GRADING AND EROSION CONTROL PLAN CHECKLIST

Grandview Reserve - Dual Force Sewer Mains

Grandview Reserve – Interceptor Sewer

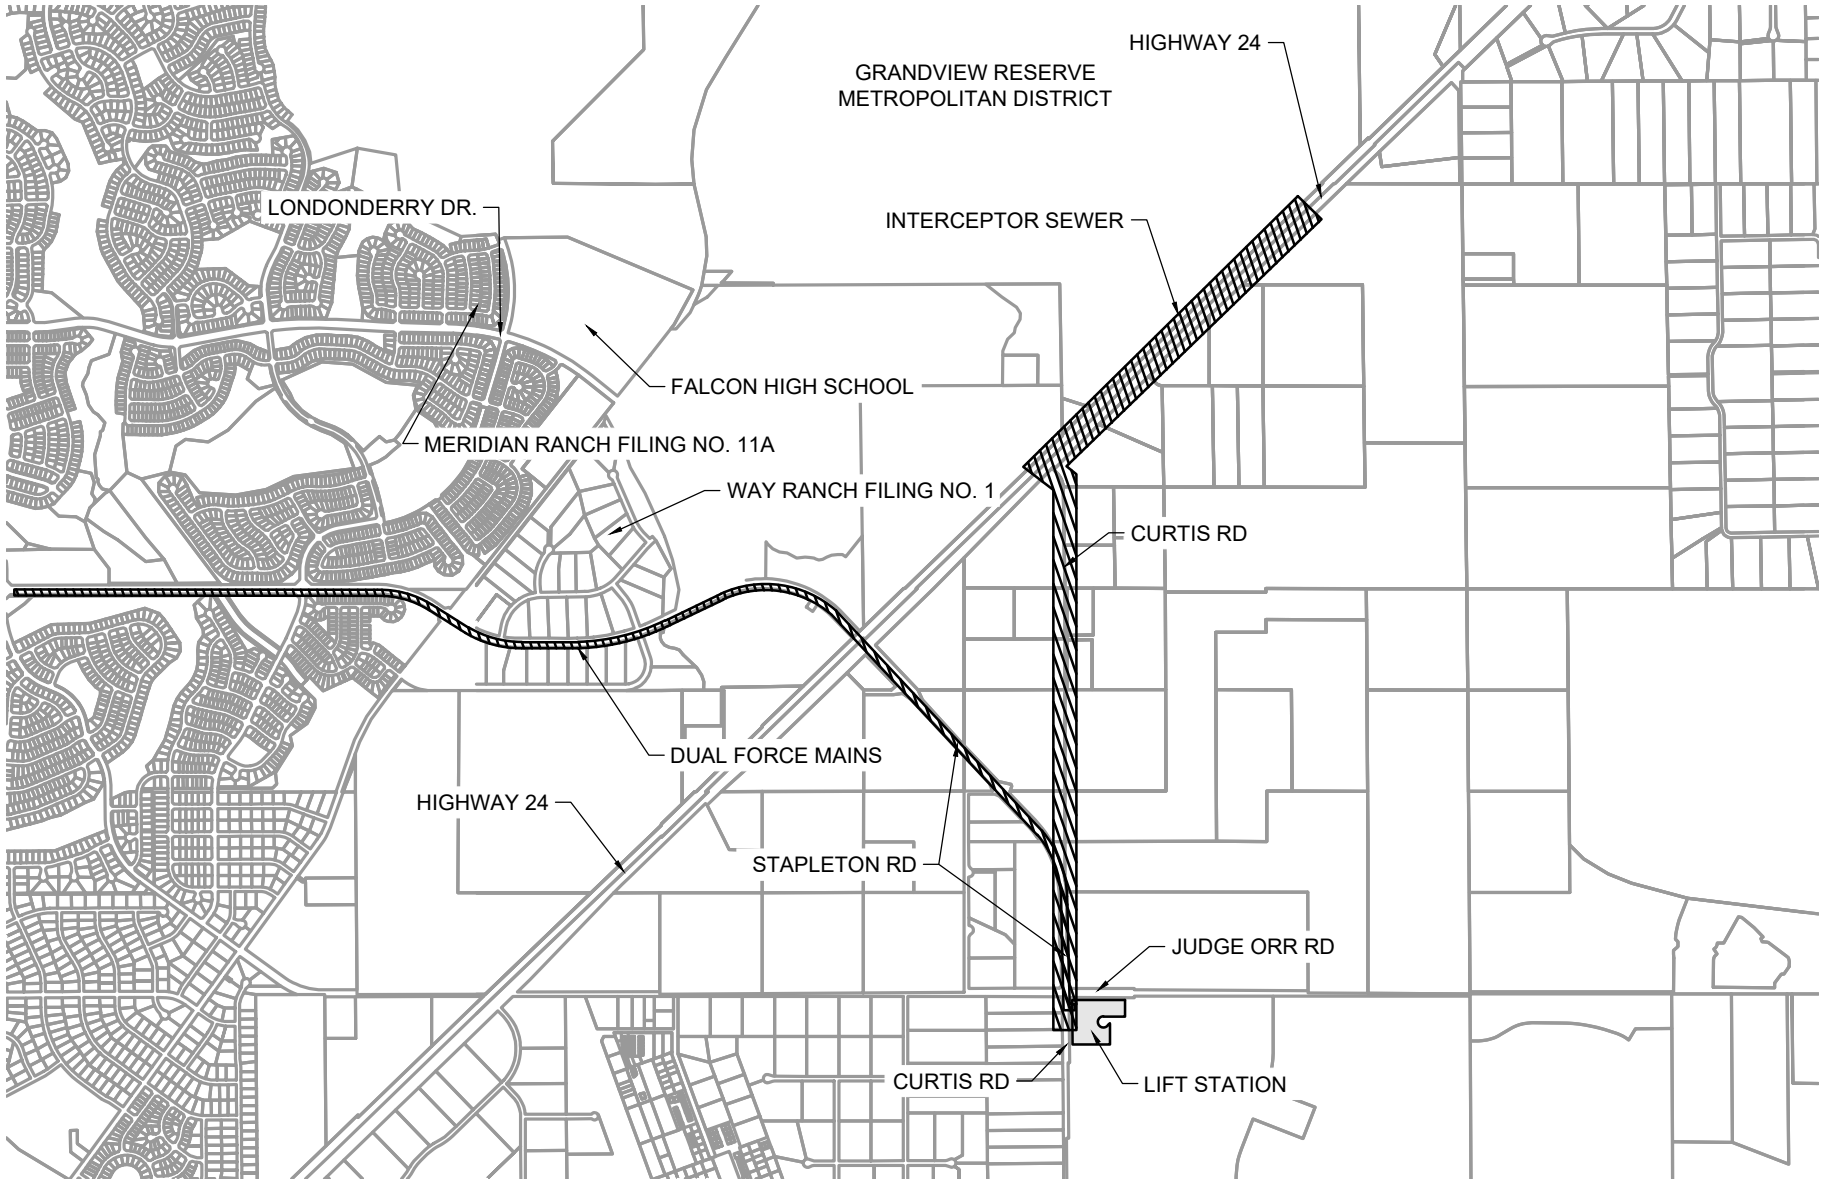
No Title Sheet included with the GEC Plans.
